Kirklees Metropolitan Borough Council -
Development Management
HUDDERSFIELD, HD1 2JR

Reference: PA-0000875/01
Customer reference: 2025/93464
15 April 2026

Demolition of existing building and erection of industrial building

Spinksmire Mill Huddersfield Road Meltham Holmfirth HD9 4AN

DRAWING NO. 1564-LRC-ZZ-XX-DR-A_1002	REVISION	P01
--------------------------------------	----------	-----

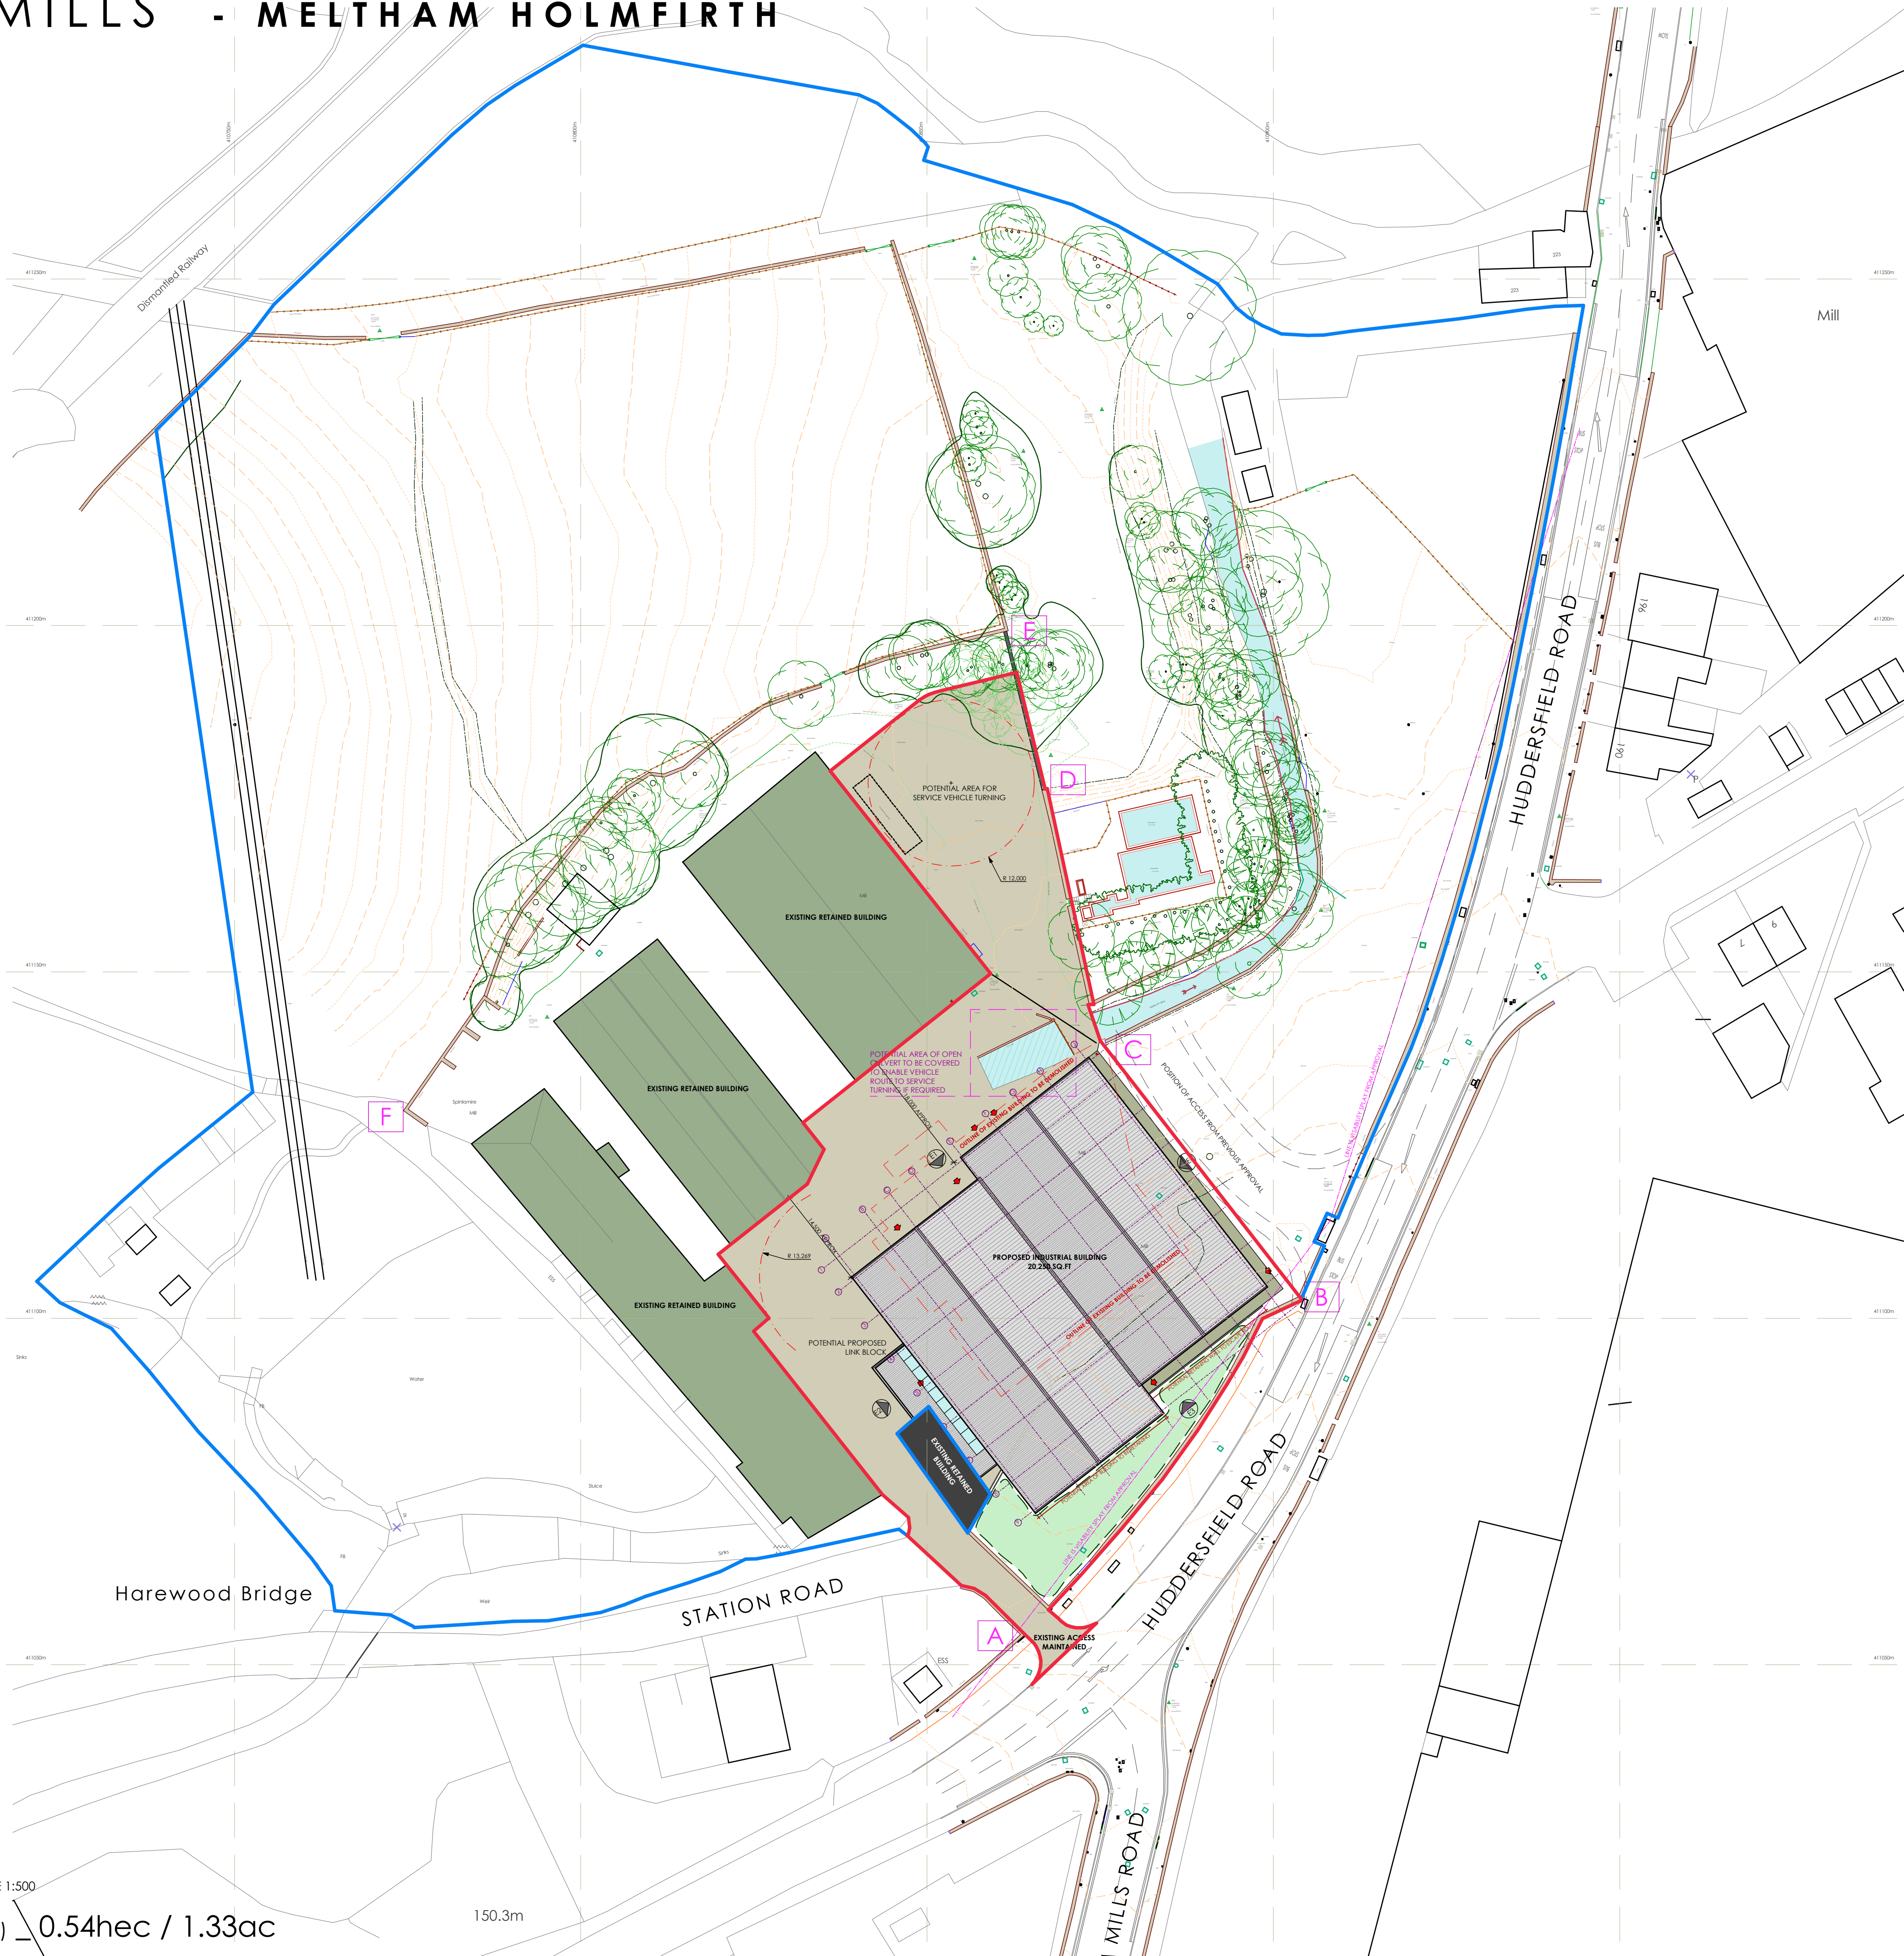
- Accurately describe the nature of the proposed development.
 - Drawing number 1564-LRC-ZZ-XX-DR-A_1002, revision P01, dated 04/02/2026 shows “potential area of open culvert to be covered to enable vehicle route to service turning if required”, however this is not addressed in the FRA. Please note, the Environment Agency is opposed to culverting of watercourses because of the adverse ecological, flood risk, geomorphological, human safety and aesthetic impacts.

To overcome our objection, the applicant should submit a revised FRA which addresses the points highlighted above.
